From: Amanda Scholes on behalf of Planning.Responses
Sent: 05 December 2017 10:27
To: Planning Scanning
Subject: FW: LU/121/17/RES - parcel C2 and part C1, B2 and B4 - email 4 of 4

From: Tim Townsend [<mailto:tim.townsend@westsussex.gov.uk>]
Sent: 05 December 2017 09:48
To: Michael Eastham
Subject: RE: LU/121/17/RES - parcel C2 and part C1, B2 and B4 - email 4 of 4

Please could I have your comments on the revised landscaping plans that were submitted by Laura Graham yesterday?

Drawing Title:
Site Layout - INFORMATION

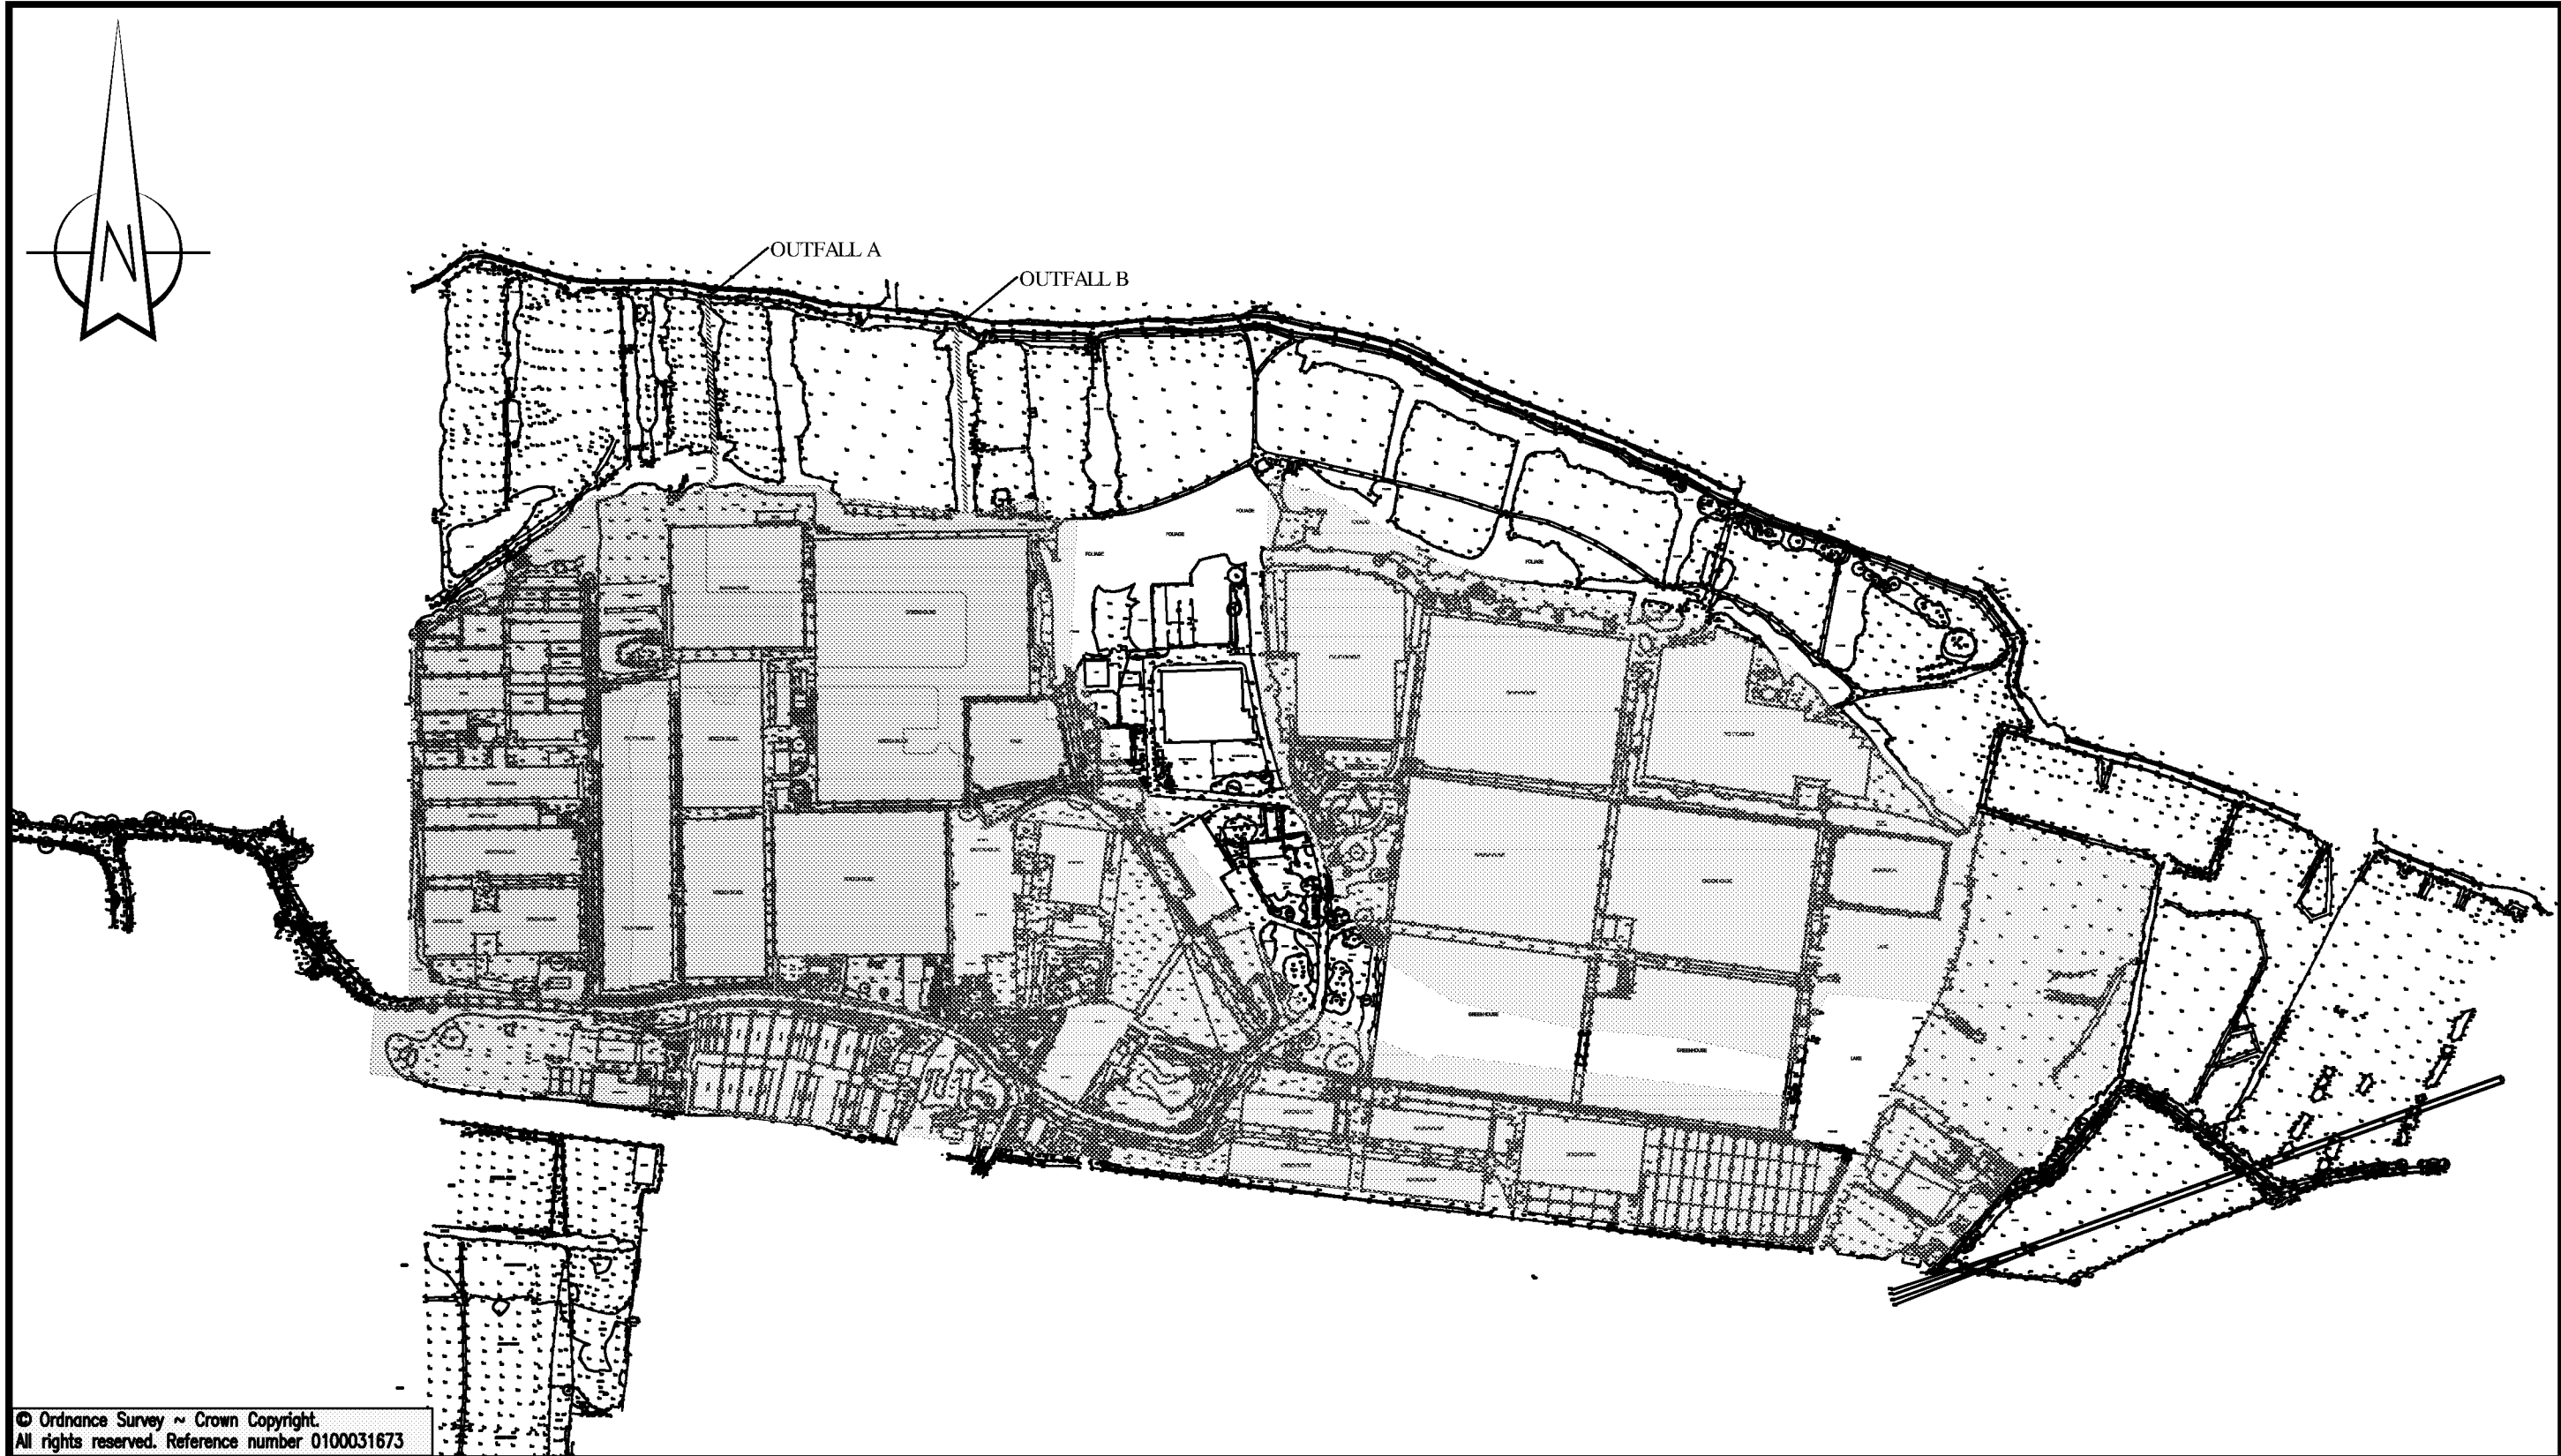
The key issue from a highway safety perspective is one of visibility and any impact the presence of trees might have on this. Although visibility splays have been shown on one of the plans, it appears to me that the pedestrian crossing points on the first section of main spine road (so the E-W section coming-in off the IDR) have trees too close to the crossing points which will mask pedestrians from drivers and vice-versa. We'd need to see clearer plans and ones showing that trees are not located as close to these crossing points. Furthermore, the 'knobbly' hard landscaping alongside the tree pits is not welcomed and presents a trip hazard to pedestrians.

When preparing revised plans, the applicant should also send them to their Road Safety Audit team for comment – the latter to be provided to both the LPA and CHA when anything new is made available.
